Agency Review Comments

Falcon Highland Sketch Plan Amendment

**FALCON HIGHLANDS FILING NO. 3
LETTER OF INTENT
SKETCH PLAN MAJOR AMENDMENT**

Letter of Intent_V1 comment Pln.pdf Markup Summary 12-7-2021

SKETCH PLAN AMENDMENT FALCON HIGHLANDS

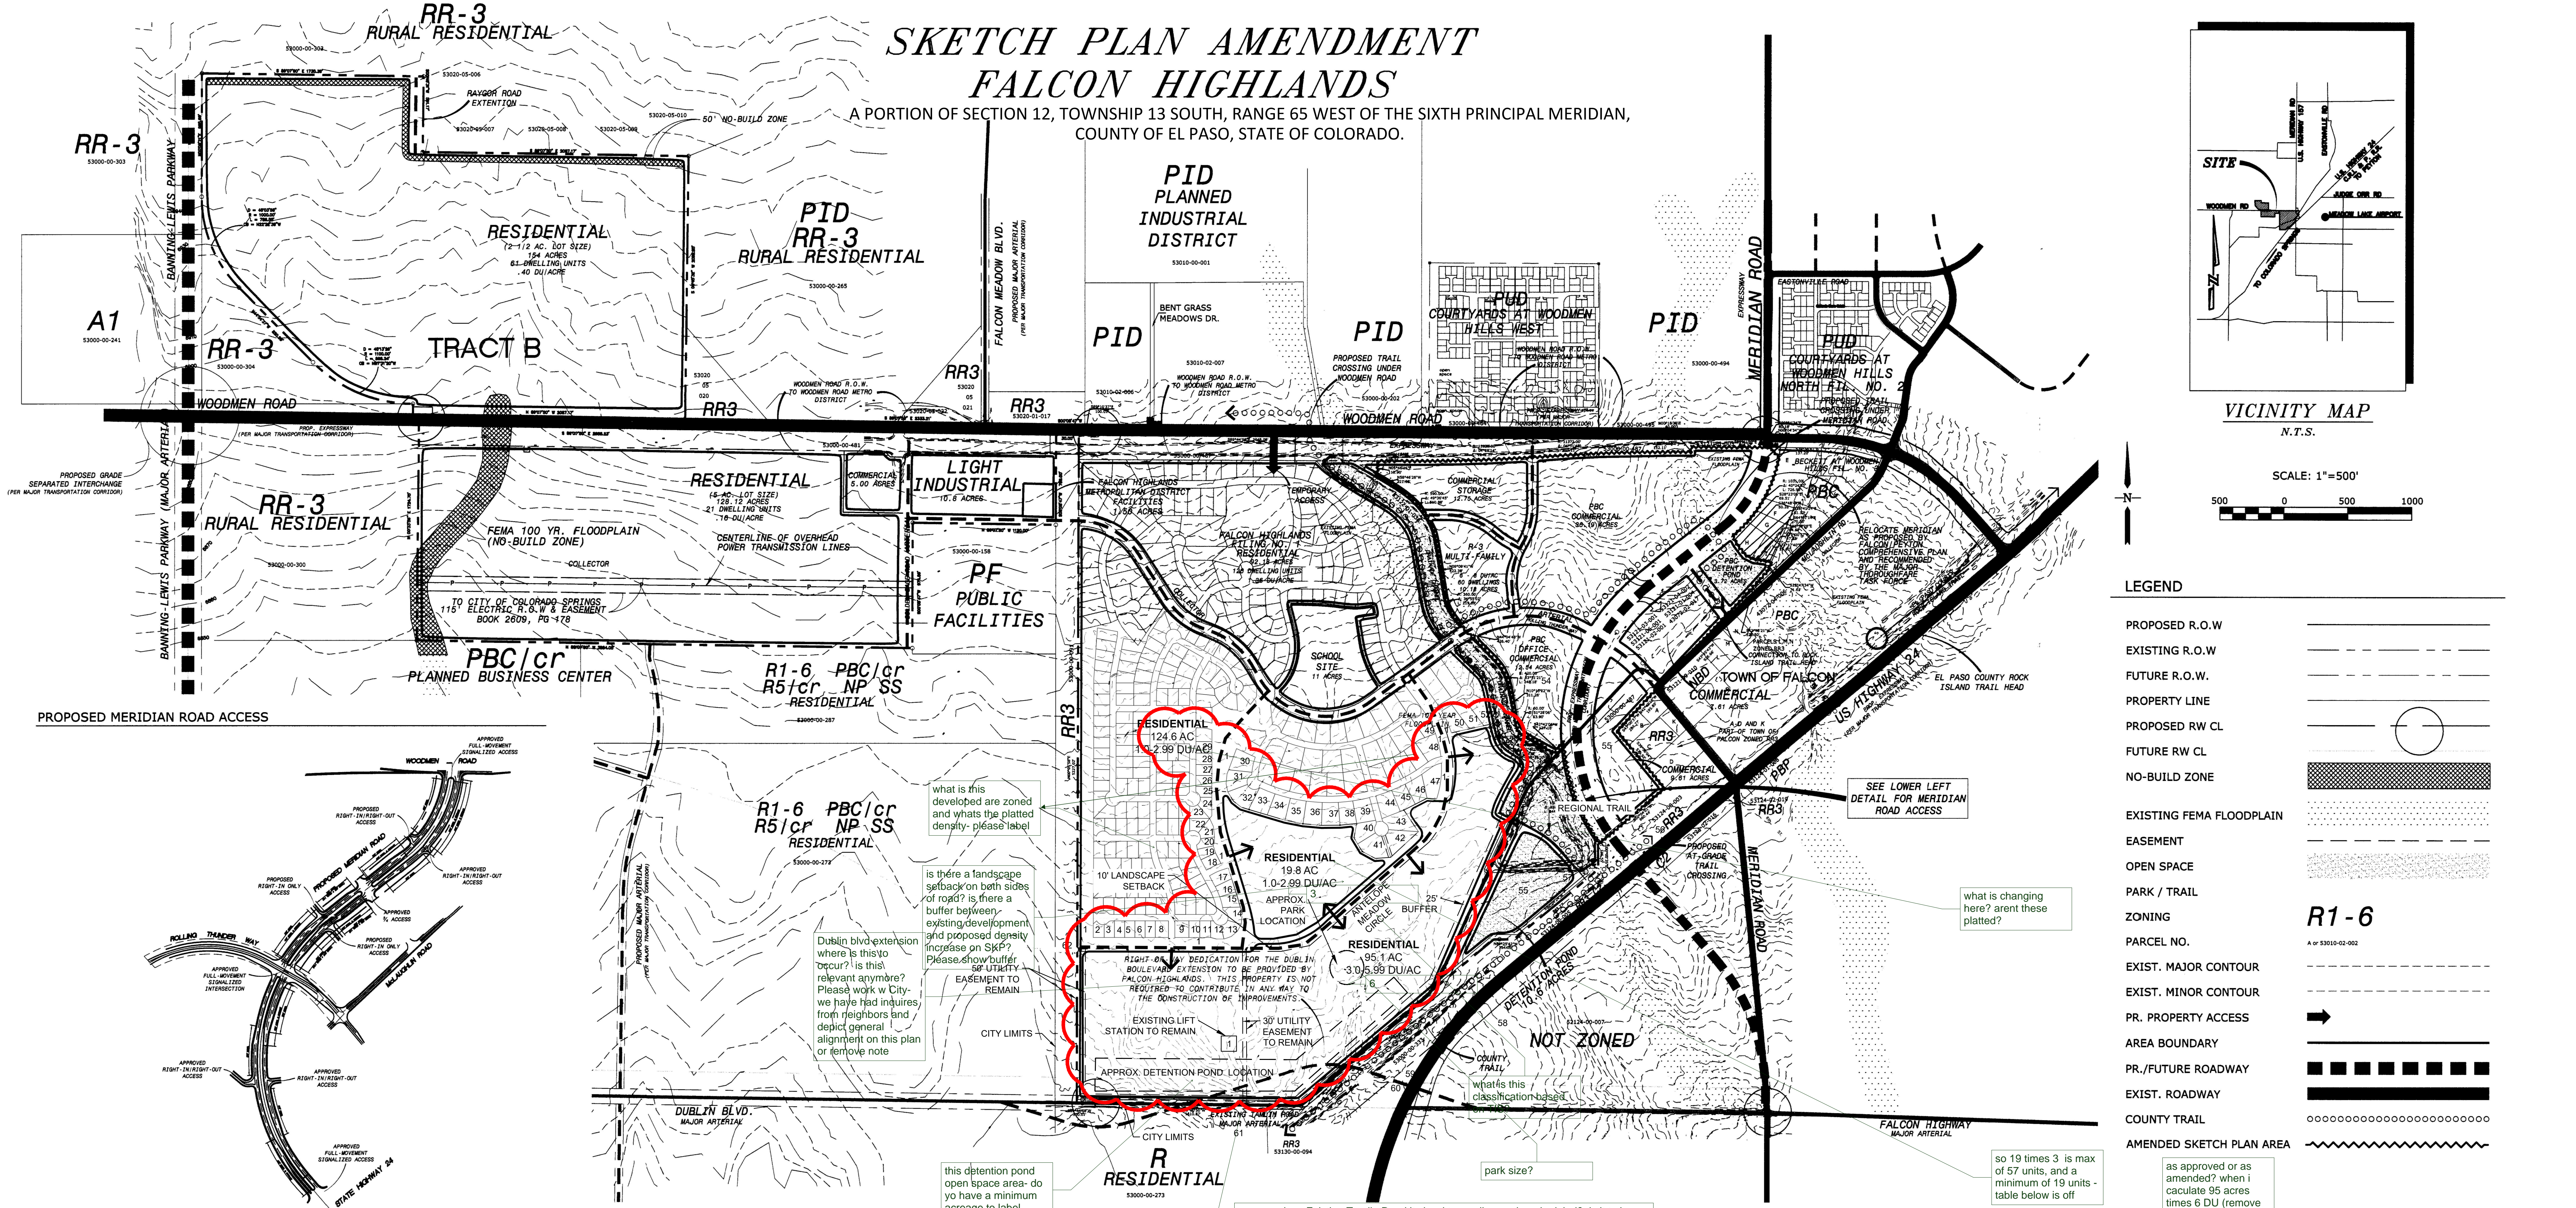
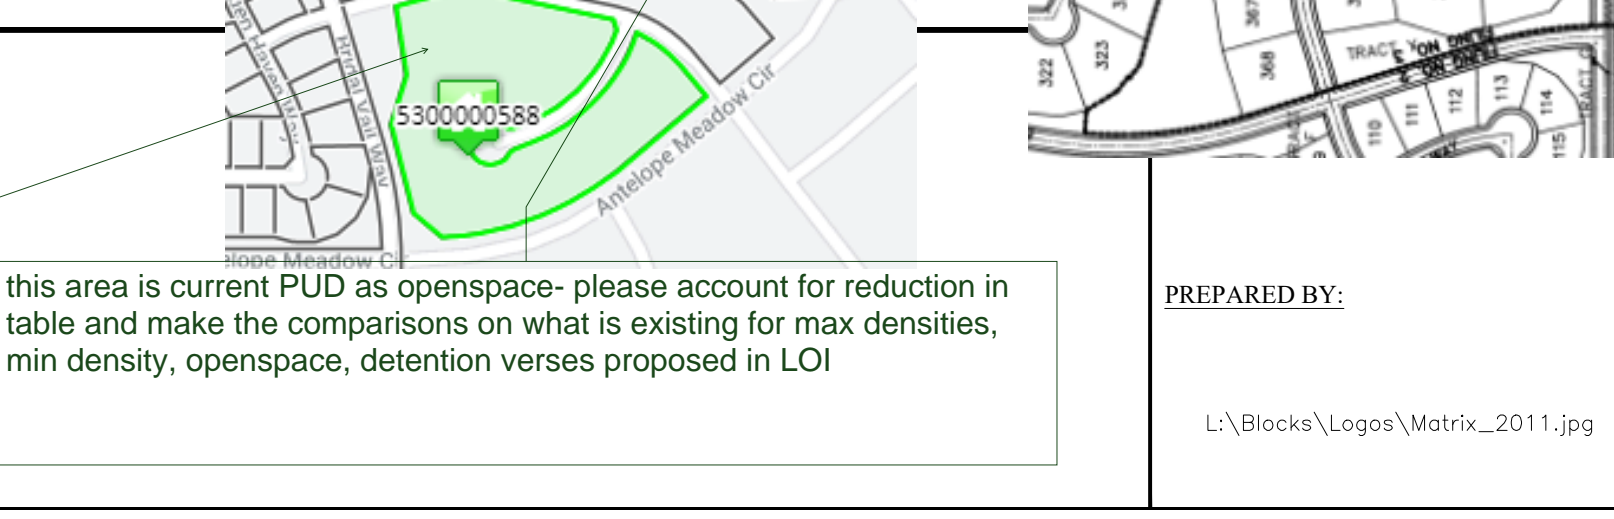
that does not add up with numbers on SKP

is does not match proposed density calcs or note on SKP

there is a drainage area depicted, and the aerial depicts a drainage adj...
